Consultee response

EP/80/20/HH & EP/81/20/L

Vista Point 21 Tamarisk Way East Preston BN16 2TE

Planning and Listed building consent to convert 2 existing garages to habitable accommodation to create a new family living space and enclose the existing outdoor link from the main house to the garage to form an indoor warm/dry link with alterations to the landscaping arrangements.

ALTERATIONS AND REPAIRS
ELEVATION 01

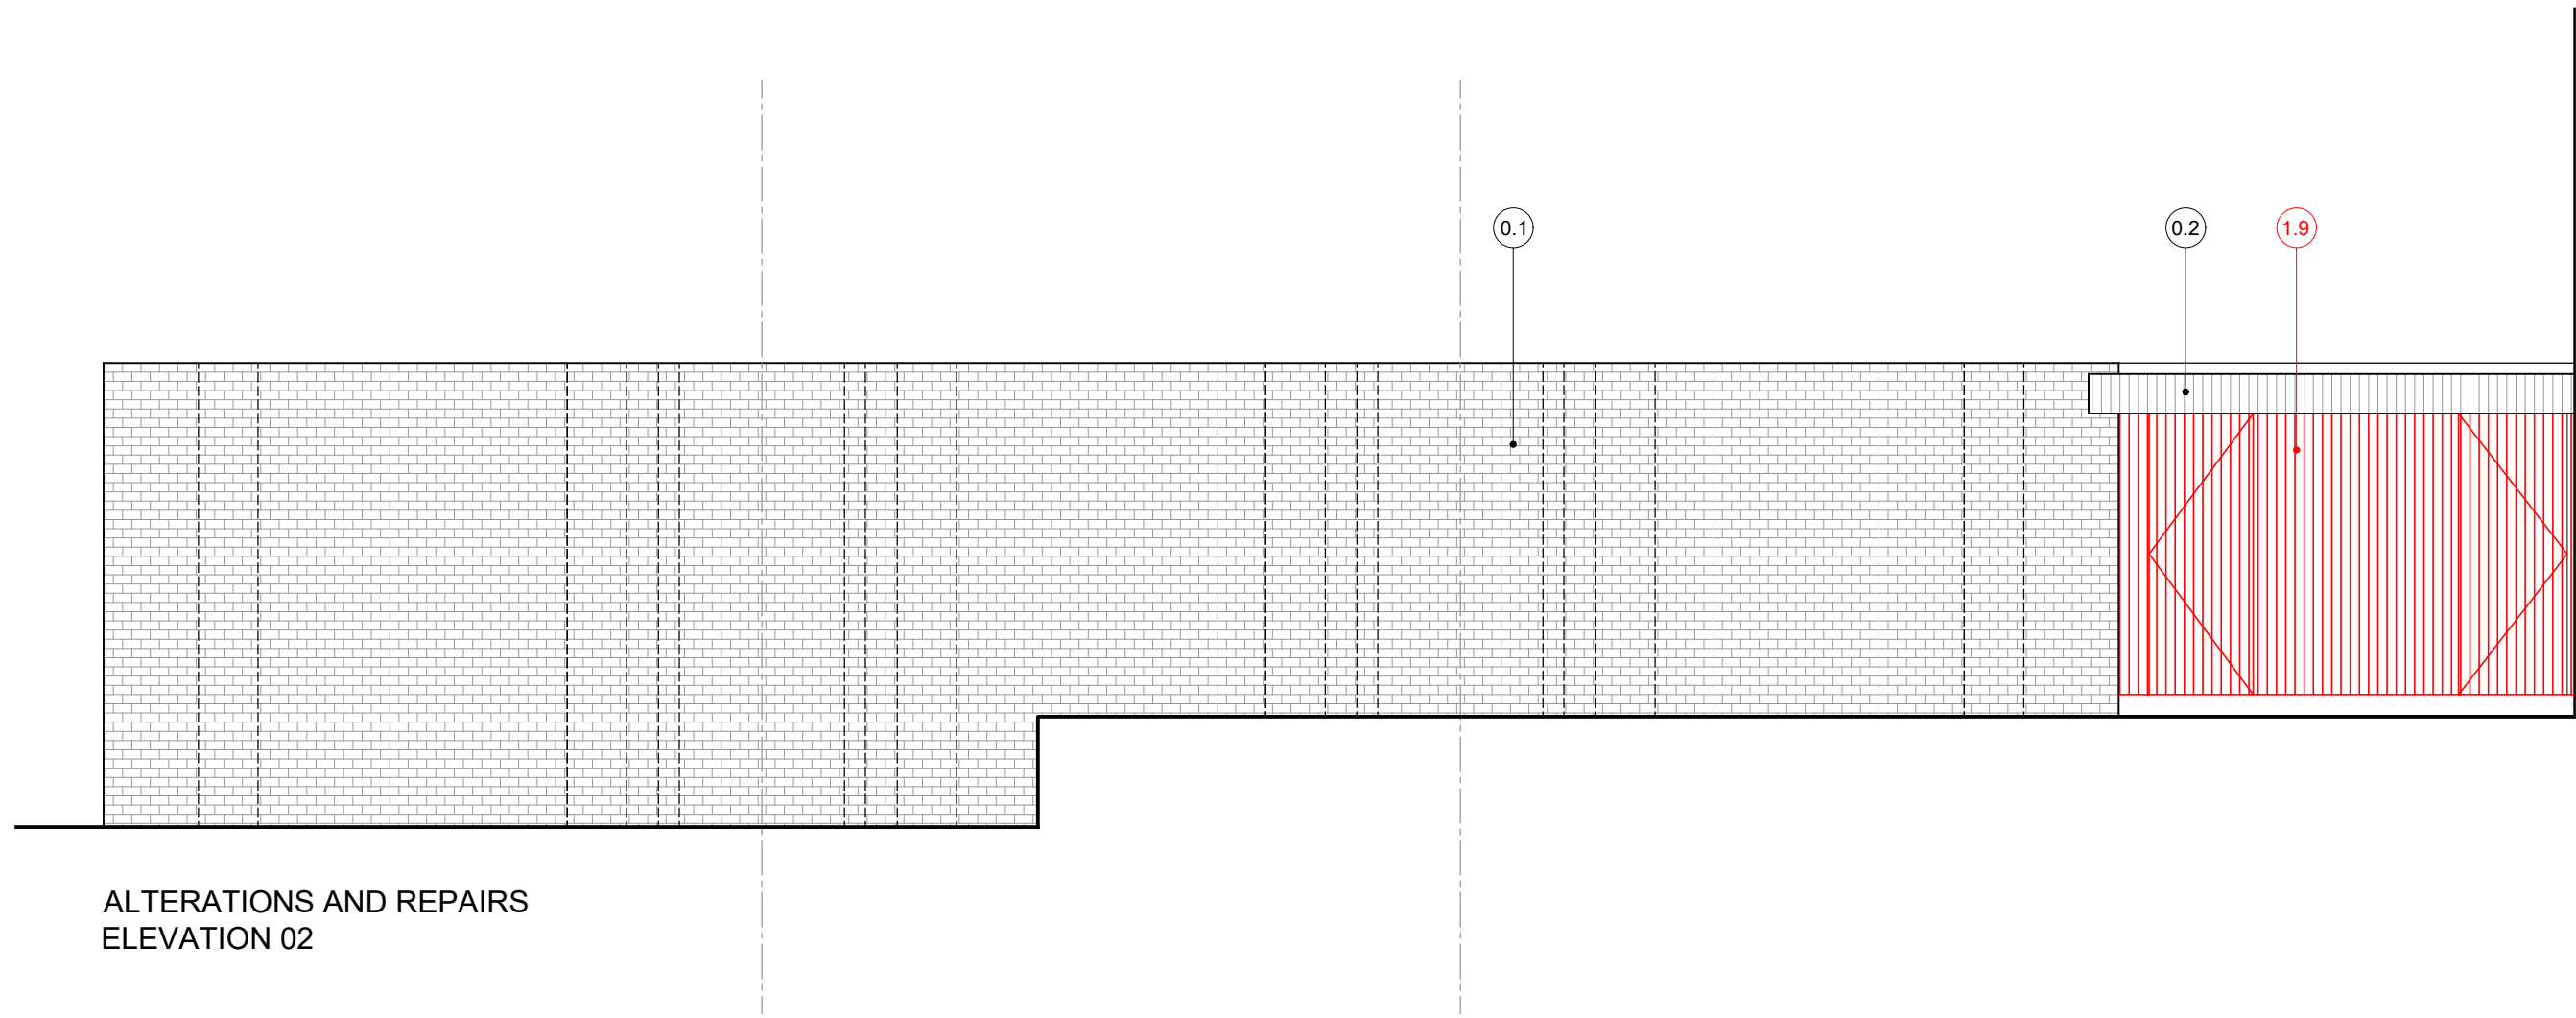
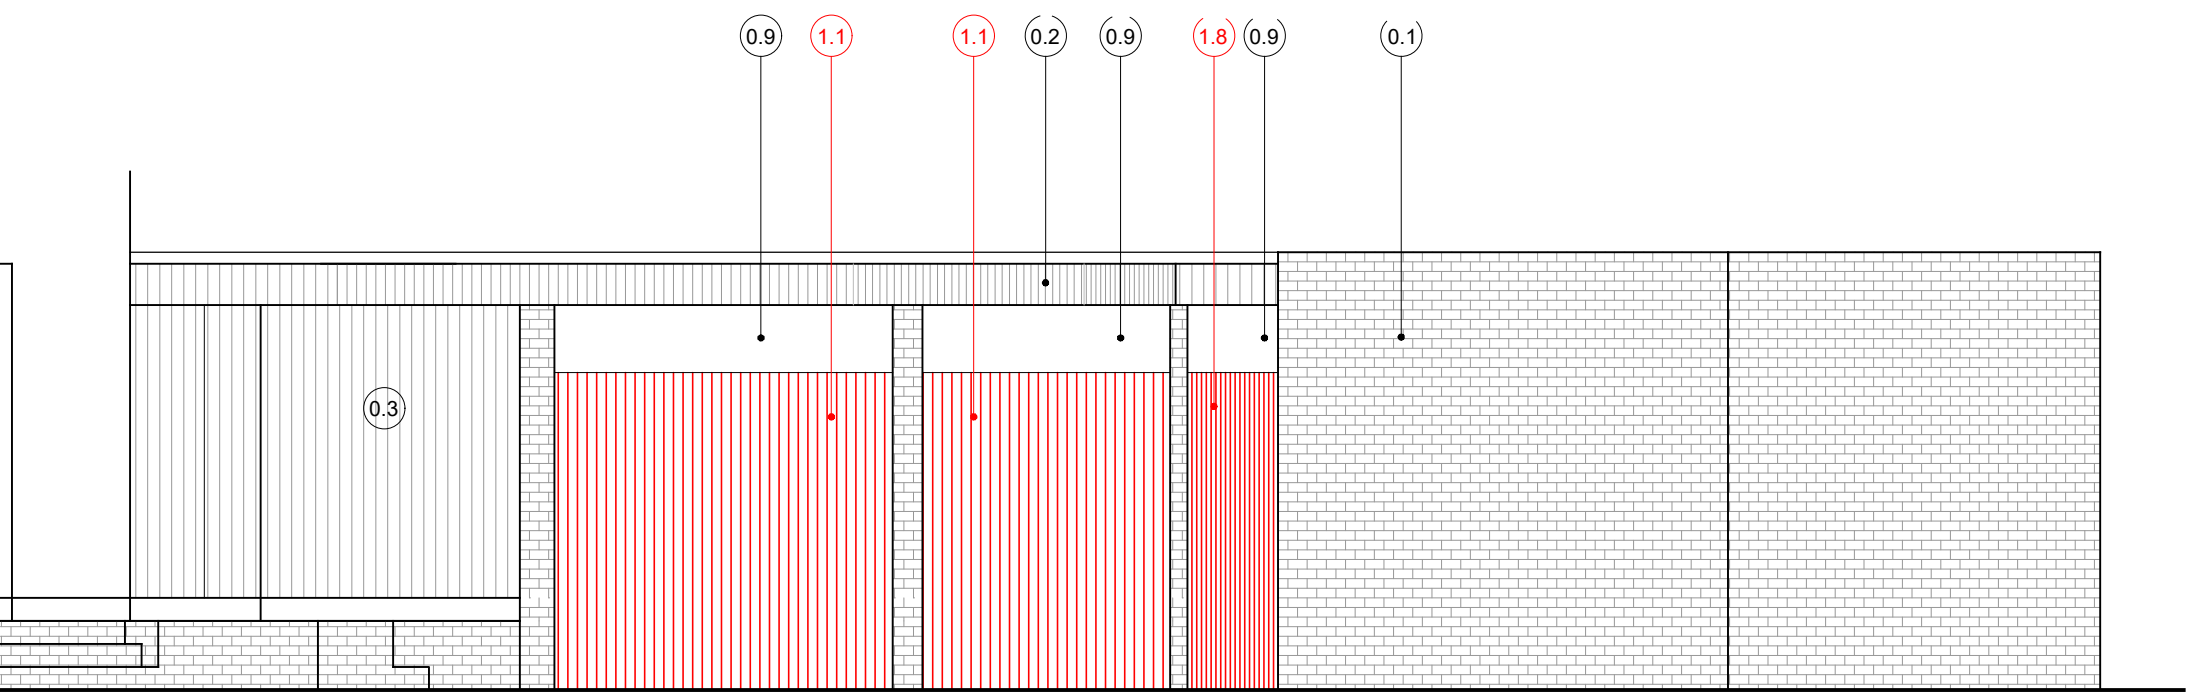
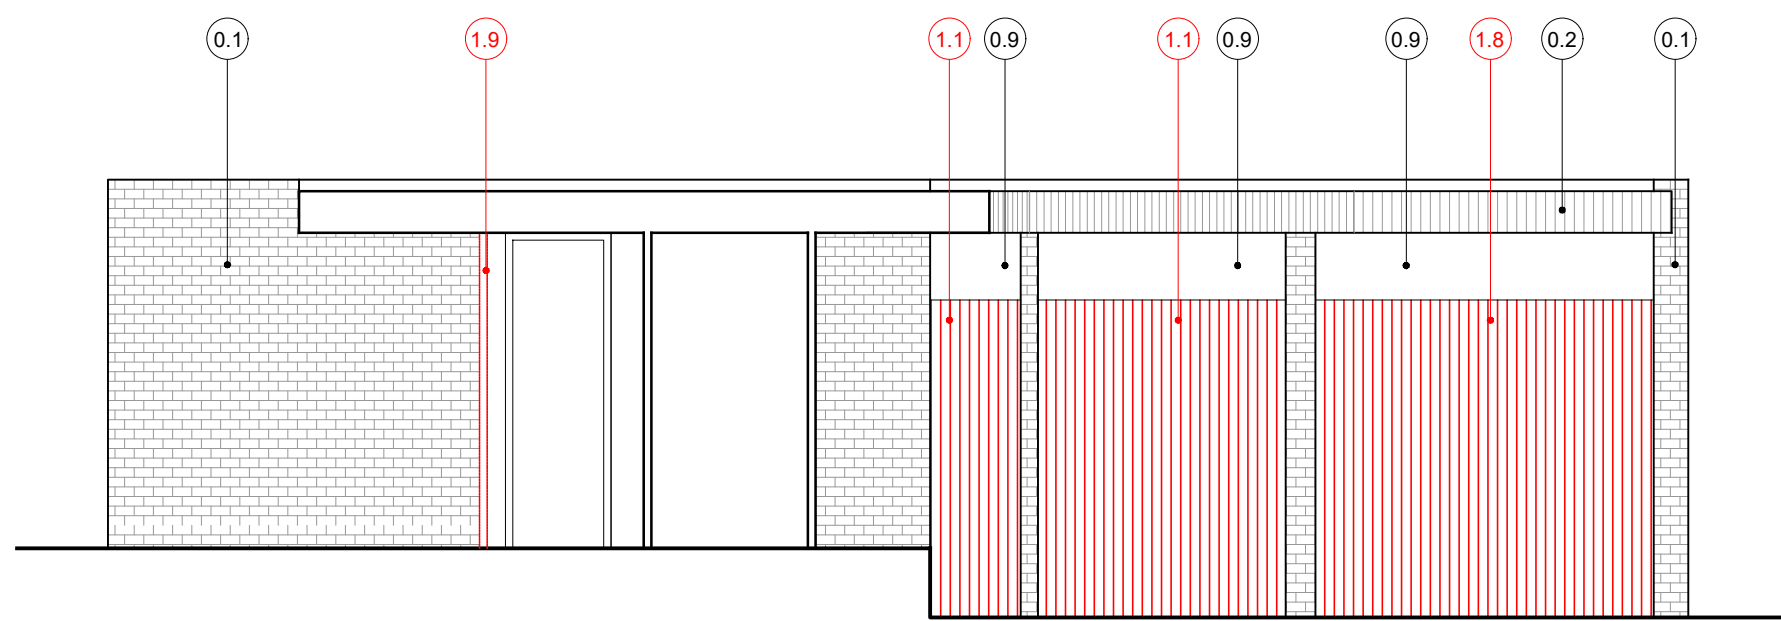
It is interesting to note on the plans proved that the original garage door remains present (note reference 0.5: Existing original door to garage). This is helpful as it indicates what the proposed new double doors could look like for the games room element of the building. It is also not clear why the original garage door is to be replaced? Is it in a poor state of repair, and unable to be salvaged?

Justification has been made for the use of the two rooflights (provide light when the doors are closed and no openings on the rear elevation), which if successfully, and carefully designed will, on balance, be acceptable. This is subject to a detailed design being approved by way of condition.

It would appear that the intention is to install new aluminium double glazed screens (item 3.1) behind the new double doors (item 3.5) of the games room. This is acceptable as it is a suitable method of providing light into the space when in use, whilst at the same time hiding the interior away from use when not. Details of the windows and doors should be provided for by way of condition, if you are minded to approve the application.

It is also noted in item 2.3 to 'Allow for ventilation between existing timber joists by installing grills in external walls. Subject to Heritage approval'. Details of this will be required in order to understand the impact that they will have on the building and the historic fabric.
